**Re: Proposed New Dwellings – Land to the Rear of St Mary's Rectory, Victoria Street, Barnsley**

I refer to our telephone conversation earlier today and enclose for your attention three copies of our drawing No 23/22/P1 Revision B which illustrates two minor amendments to the drawing lodged with the Planning Application.

PLANS AND ELEVATIONS

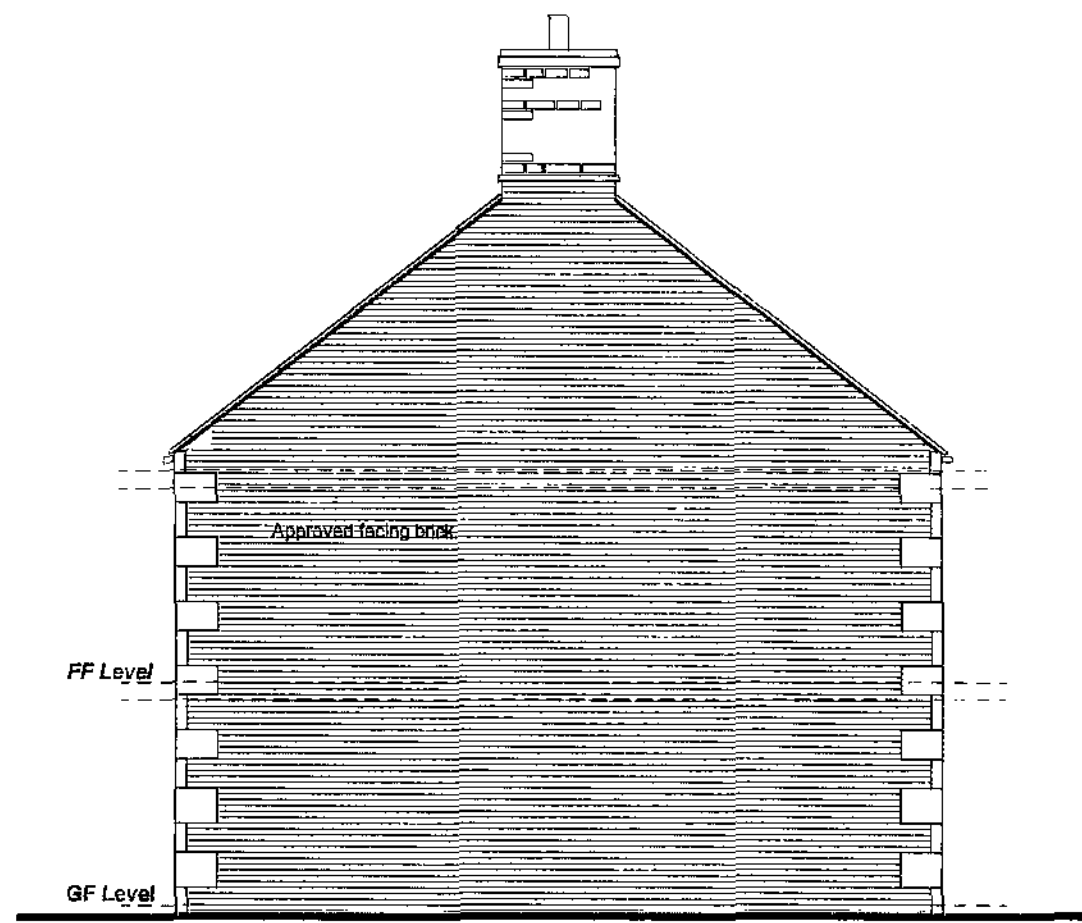
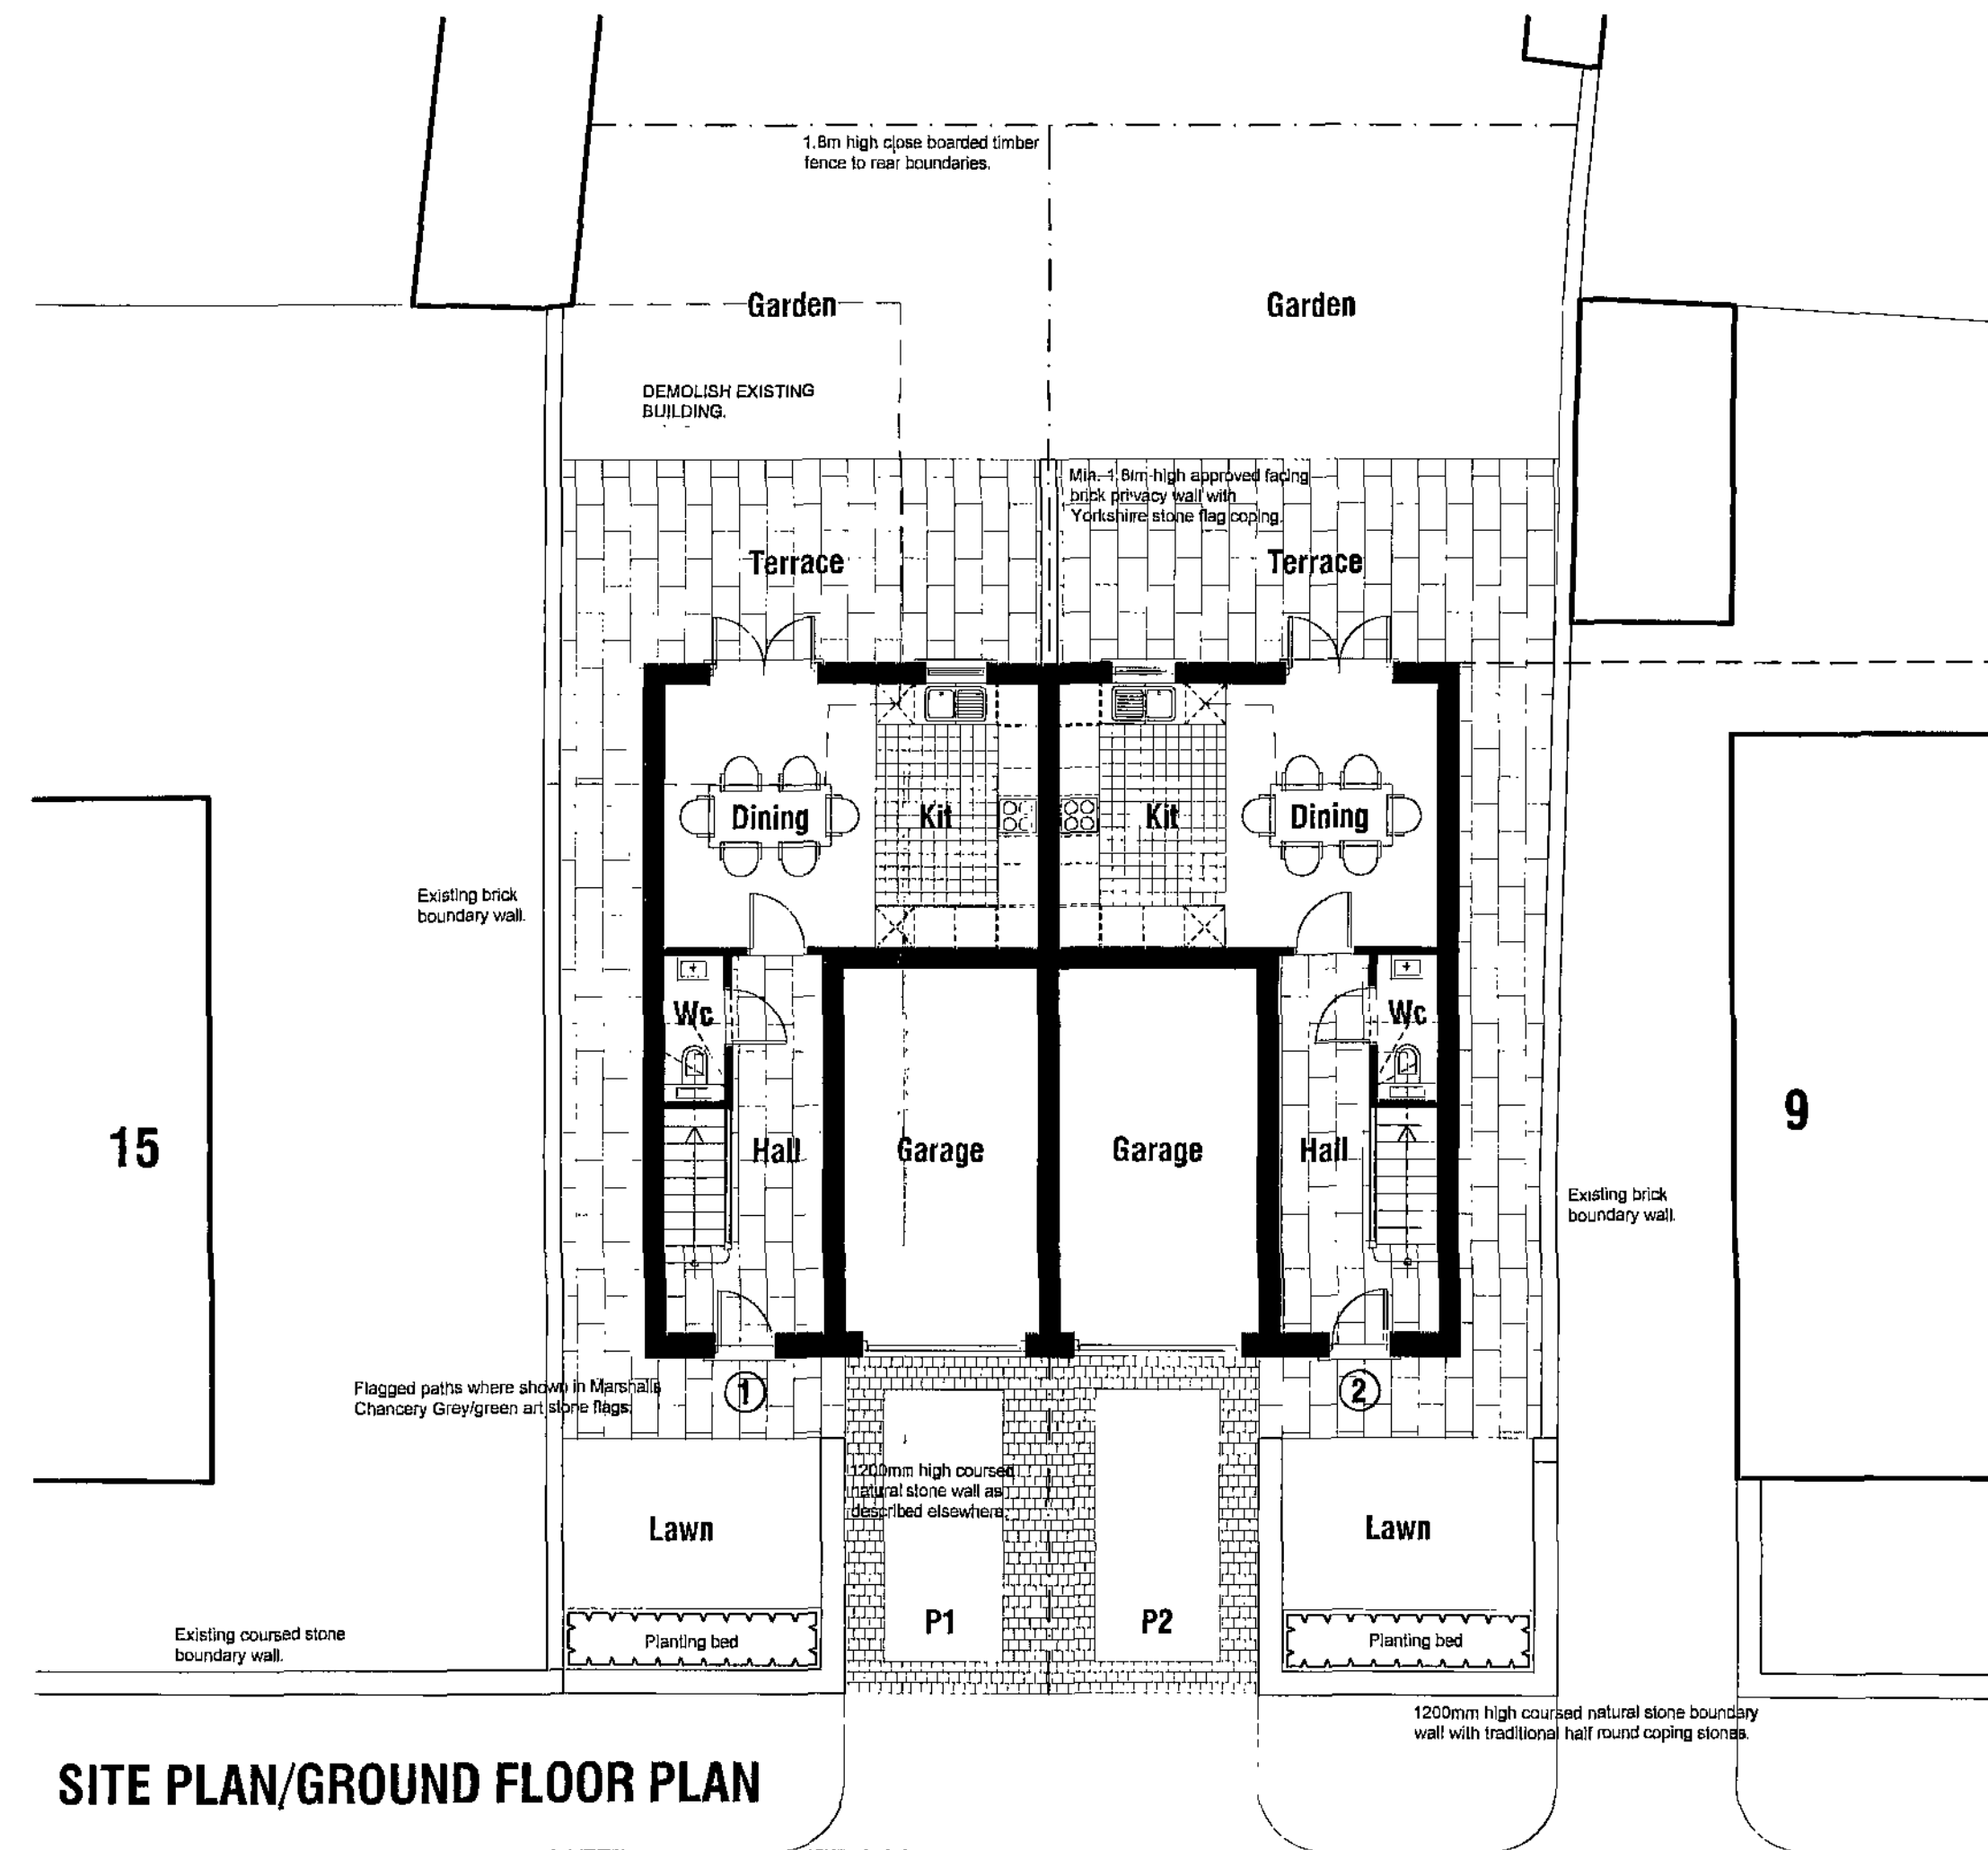
1. Our clients have asked us to omit the gable coping to the roof as they have had past difficulties with regard to maintenance. The detail is not typical of houses within the immediate area and I believe that there would be no major design issue caused by the omission proposed.
2. Our clients are anxious to separate the proposed development site from the existing Vicarage as quickly as possible to enable marketing of the Vicarage before it becomes subject to vandalism. In the circumstances, they have asked us to amend our proposals to omit the new 1.8m high brick wall and to substitute this with a 1.8m high close boarded timber fence. Again, the boundaries in question will be invisible to the public and will have no effect upon the surrounding Conservation Area. I do not believe there will be any design impact by making the change.
